8 City View Rd, Peaks Island - Shoreland alteration project

It has recently come to this office's attention that you have applied for a state Natural Resources Protection Act (NRPA) permit to remove vegetation, install rip-rap, and install access stairs at property located at 8 City View Rd on Peaks Island.

ATTACHMENT 5

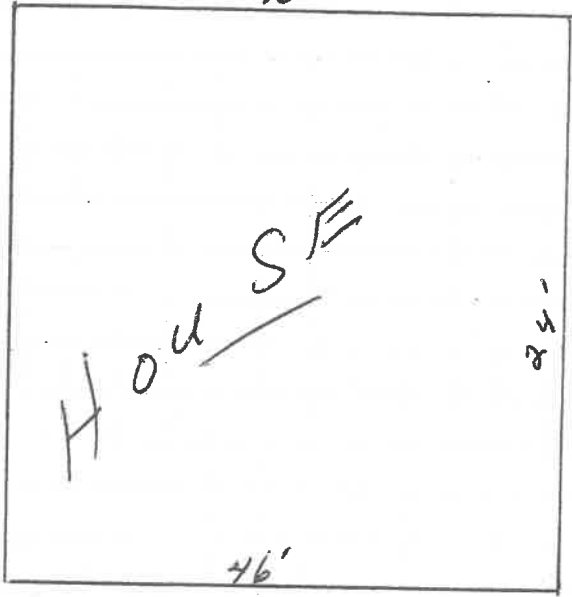
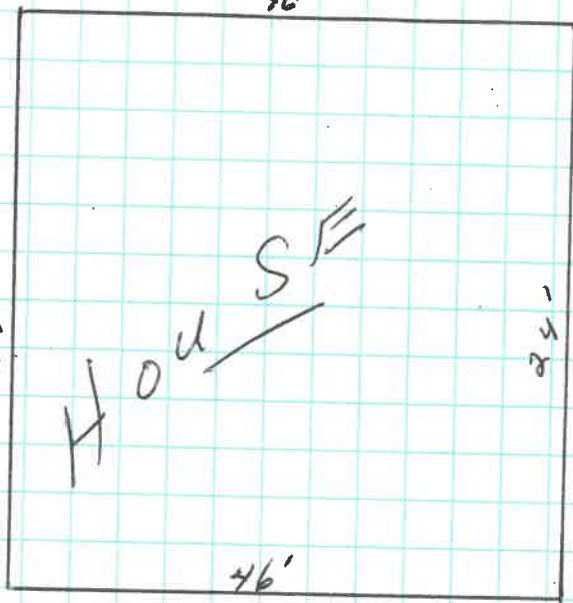
With the Planning Dept, site plan review will be required. I believe this would fall under a Level II Site Plan ([checklist here](#)) due to the placement of new structures including the stairs within the Shoreland Zone.

Of particular concern on your project is the proposed clearing of vegetation. Clearing for the placement of the rip-rap is to be expected, but the proposal further requests the removal of all shrubs from the slope above the rip-rap, to be replaced with virginia rose shrubs. As part of your city review, you will need to provide an inventory of what is to be removed (species list and approximate number/area of each) as well as a justification for removal. Is it necessary for the stabilization project? Is it simply for aesthetics? Is it for removal of invasive species? If the latter, you need to explain how removal will be accomplished and provide a maintenance plan to address regeneration issues. We would ask to see a replanting plan with a variety of native species, and the planting area will also need to extend towards the house (into the lawn) to replace a similar area of vegetation that will be lost by placement of the rip-rap.
